V2 will require a landscape plan showing your proposed/existing landscaping as the landscape code is applicable to all uses.

6.2.2 Landscape Requirements

WOODMEN HILLS WASTEWATER			
WOODMEN HILLS METRO 100% CONSTRUCTION DOCUMENTS			
LANDSCAPE PLAN			
DESIGNED BY:	MDF	SCALE:	DATE ISSUED:
DRAWN BY:	KGI	HORIZ:	JULY 2025
CHECKED BY:	MDF	VERT:	SHEET
			6 OF 8
DRAWING No.			LS01

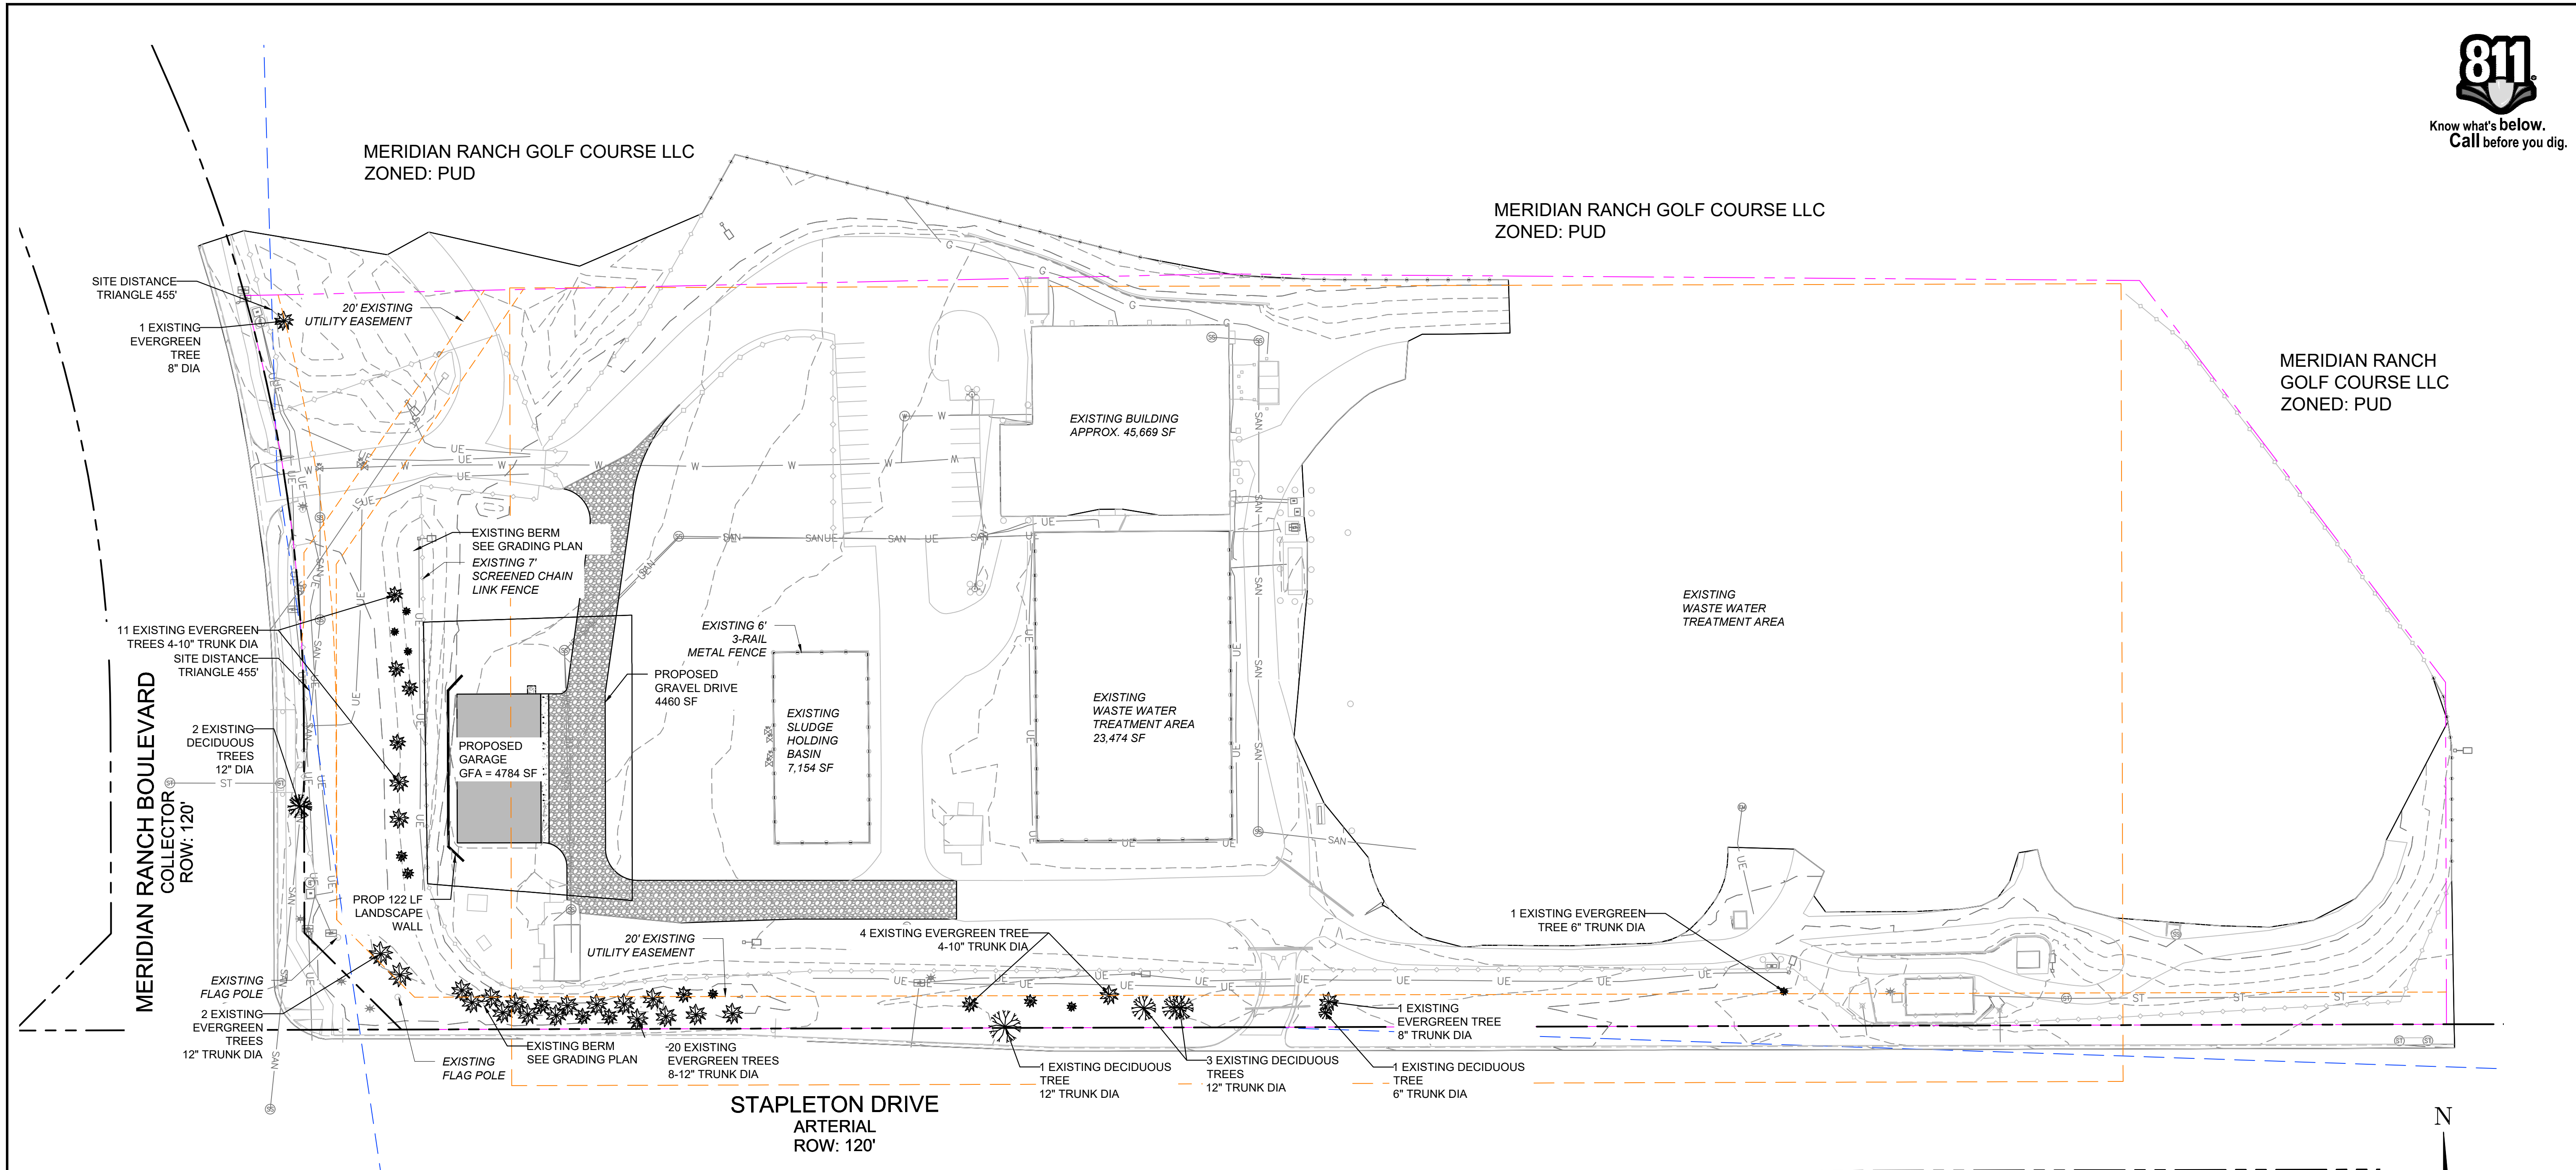
The request for a substitution does not negate the requirements of this section. Please show where you will be substituting landscaping. Landscape plan checklists are available at:
